HINCKLEY NATIONAL RAIL FREIGHT INTERCHANGE

Appendix 12 - M69 J2 Road Safety Audit Stage 1 Response Report

M69 J2 Stage 1 Road Safety Audit
RESPONSE REPORT

Report Title:	Hinckley National Rail Freight Interchange – M69 J2 Stage 1 RSA Response Report
Document Number:	HRF-BWB-HGN-RSA-RP-CH-0005
Prepared By:	BWB Consulting Ltd
Overseeing Organisation:	Leicestershire County Council & National Highways
BWB Reference:	NTT2814

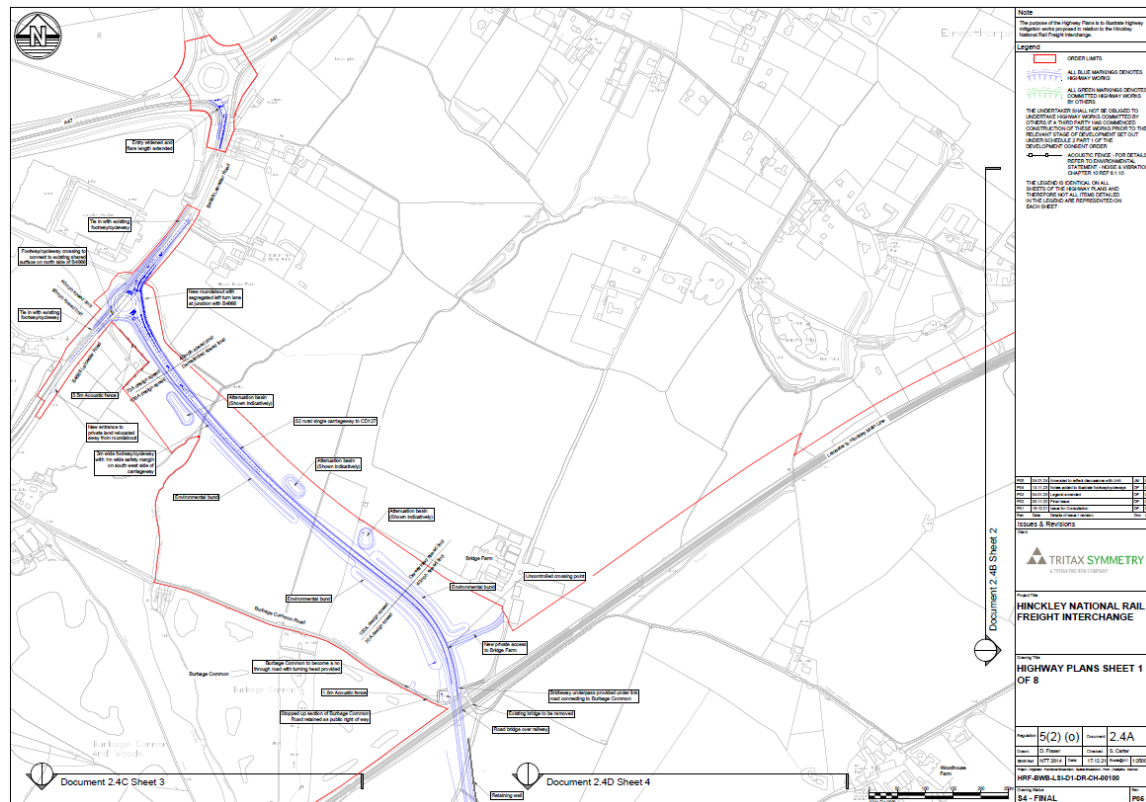
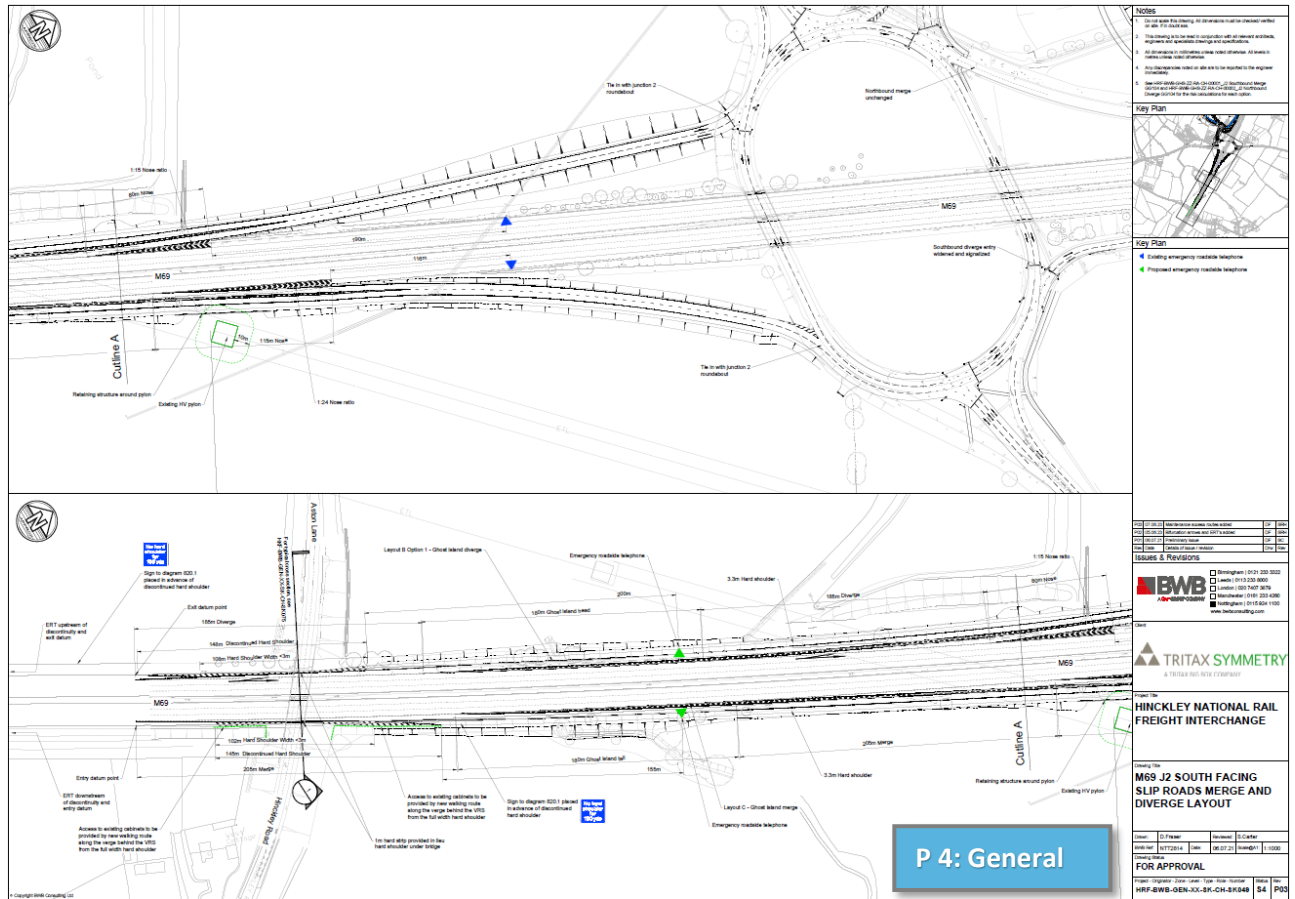
RSA Ref.	RSA Problem and Recommendation	Design organisation response	Overseeing organisation response	Agreed RSA action
3.2	<p>Location: M69 J2 southern circulatory carriageway.</p> <p>Summary: Confusing road markings risk side swipe type collisions.</p> <p>Around the southern carriageway of the circulatory the lane destinations show an “ahead” and a “right turn” arrow. However, approaching the junction and on the approaches before this point, “ahead” and “ahead and right” arrows are shown. This could lead to late lane changes, sudden and unexpected braking and side swipe type collisions due to driver confusion and late decision making as a result of confusing and misleading lane destinations.</p> <p>Recommendation:</p> <p>It is recommended that the markings are amended so that they are consistent with the available movements around the southern half of the circulatory and on the westbound link road exit.</p>	<p>Agree with RSA Recommendation: Yes</p> <p>Road markings on the circulatory will be reviewed during detailed design to ensure consistency.</p>	<p>Problem and Design Organisation's recommendation accepted</p>

RSA Ref.	RSA Problem and Recommendation	Design organisation response	Overseeing organisation response	Agreed RSA action
3.3	<p>Location: M69 southbound approach to the new signalised junction.</p> <p>Summary: Poor forward visibility of signals risks late braking and junction overshoot type collisions.</p> <p>The southbound off-slip approach to the proposed signals at Junction 2 has a significant vertical and horizontal alignment change on the approach to the current Give-Way line. There is a concern that, given these changes and the existing signing infrastructure, that forward visibility towards the signal heads will not be provided for vehicles.</p> <p>Recommendation:</p> <p>It is recommended that the signals are located and designed, including raised poles and/or gantry signals if needed, so as to provide adequate forward visibility for approaching vehicles. Furthermore, it is recommended that the signing on the approach is amended so as not to pose an obstruction.</p>	<p>Agree with RSA recommendation: Yes</p> <p>Visibility on the existing southbound diverge slip road has been assessed and full stopping sight distance compliant with CD 122 and the design speed of the slip road (70kph) will be made available through the detailed design incorporating site clearance works and relocation of existing signage to ensure that there are no significant obstacles within the visibility envelope.</p>	<p>Problem and Design Organisation's recommendation accepted</p>

3.4	<p>Location: M69 southbound approach to the new signalised junction.</p> <p>Summary: Amended stop line position risks loss of control type collisions and shunts.</p> <p>The provision of the stop line at the signalised off-slip means that the existing high friction surfacing will be substandard in length. This could lead to loss of control collisions or shunts involving late braking vehicles.</p> <p>Recommendation:</p> <p>It is recommended that, as part of the detailed design, the length of high friction surfacing is amended to consider the amended stop line position.</p>	<p>Agree with RSA recommendation: Yes</p> <p>The surfacing of the roundabout and approaches to stop lines will be assessed in accordance with the relevant DMRB standards and appropriate PSV surface course will be specified through the detailed design.</p>	<p>Problem and Design Organisation's recommendation accepted</p>

RSA Ref.	RSA Problem and Recommendation	Design organisation response	Overseeing organisation response	Agreed RSA action
3.5	<p>Location: M69 southbound approach to the junction.</p> <p>Summary: Amended signing missing diversion information risks late manoeuvres and shunts / side swipe collisions.</p> <p>Whilst it is appreciated that the sign design is at a preliminary stage, the proposed signing eliminates / does not include the existing diversion route symbol. This could result in confusion for drivers following the diversion route, resulting in late lane changes and shunt type collisions.</p> <p>Recommendation: It is recommended that, as part of the detailed design, the diversion route symbols are included where appropriate.</p>	<p>Agree with RSA recommendation: Yes</p> <p>Through the detailed design, the relevant asset lead for diversion routes within NH will be contacted and diversion route symbols provided where required. This exercise will also take into account the provision of the new link road through the development as a potential new diversion route should this be desired by NH.</p>	<p>Problem and Design Organisation's recommendation accepted</p>

4.1	<p>Between J2 on the M69 and the first internal roundabout it is proposed to install a Pegasus crossing. The crossing is shown as a single stage crossing for all users, with the roundabout to the north shown as only a two-arm junction at this time. The crossing is approximately 18m in length - as part of the detailed design it should be ensured that the crossing timings and on-crossing detection account for slow moving equestrians, especially as the central splitter island is not of sufficient width for equestrian or cyclists to safely wait..</p>	<p>Noted. Crossing timings will be specified at detailed design with due regard for all potential users of the crossing.</p>	<p>Problem and Design Organisation's recommendation accepted</p>
